Your ref: SSD-71680710

Our ref: ARC24/6678

Council advice on Gara BESS (SSD-71680710) Environmental Impact Statement

Appendix I – Tree Removal for Access Upgrade and Sight Analysis

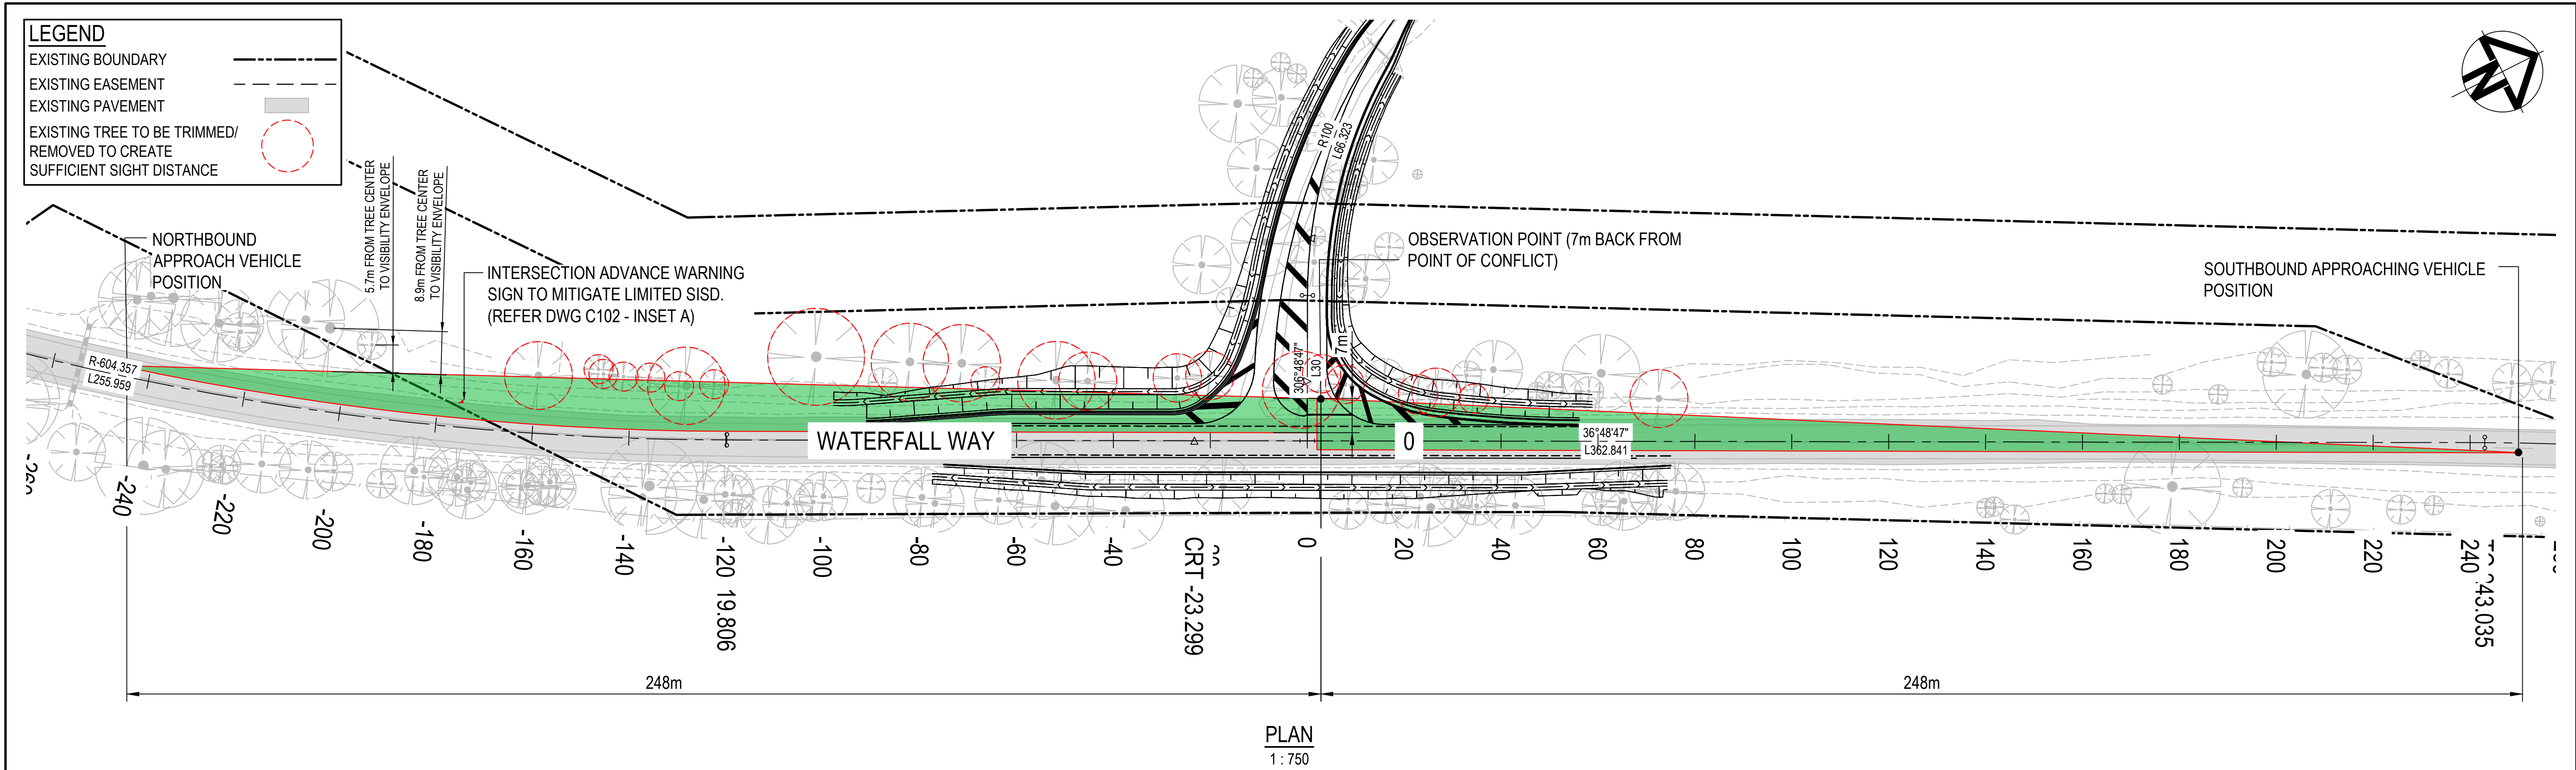
Council acknowledges that the proposed intersection upgrade will be subject to a Works Authority Deed process with Transport for NSW (TfNSW). However, it is strongly recommend that the proposed site access be modified to square the intersection to 90 degrees. This adjustment is considered necessary due to the nature and frequency of heavy and OSOM vehicle movements anticipated during construction.

Of particular concern is the available sight distance at the proposed access point along Waterfall Way. The TIA indicates that the sight distance for eastbound drivers (approaching from Armidale) is approximately 230 m, which is below the minimum 250 m Safe Intersection Sight Distance recommended under Austroads for a 100 km/h speed zone. While the westbound sight distance is slightly better (260 m), it is still only marginally compliant.

Project	GARA BESS (ARMIDALE) STRATEGIC INTERSECTION DESIGN
Title	MINIMUM GAP SIGHT DISTANCE (MGSD) SITE ACCESS PLAN

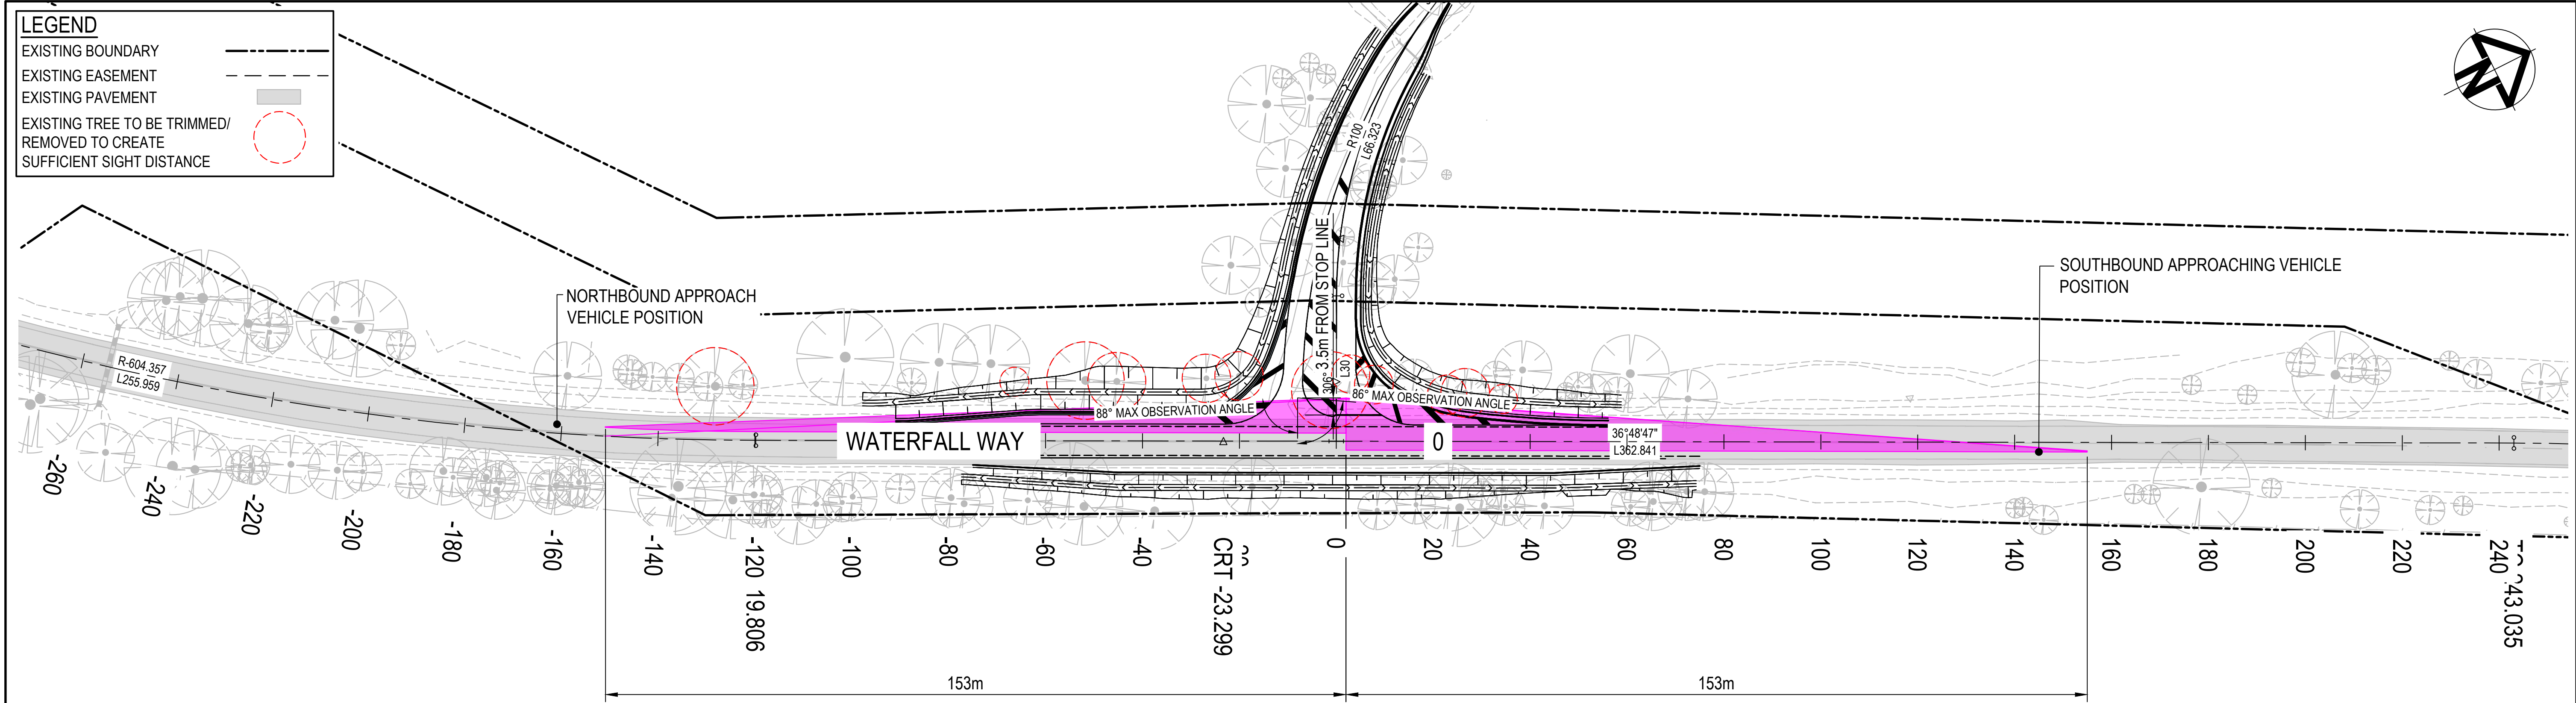
Given these constraints, and the known risks associated with large vehicle turning movements, Council considers that design measures to further mitigate safety risks are warranted. A squared intersection would improve visibility and turning geometry and reduce potential conflict with through traffic.
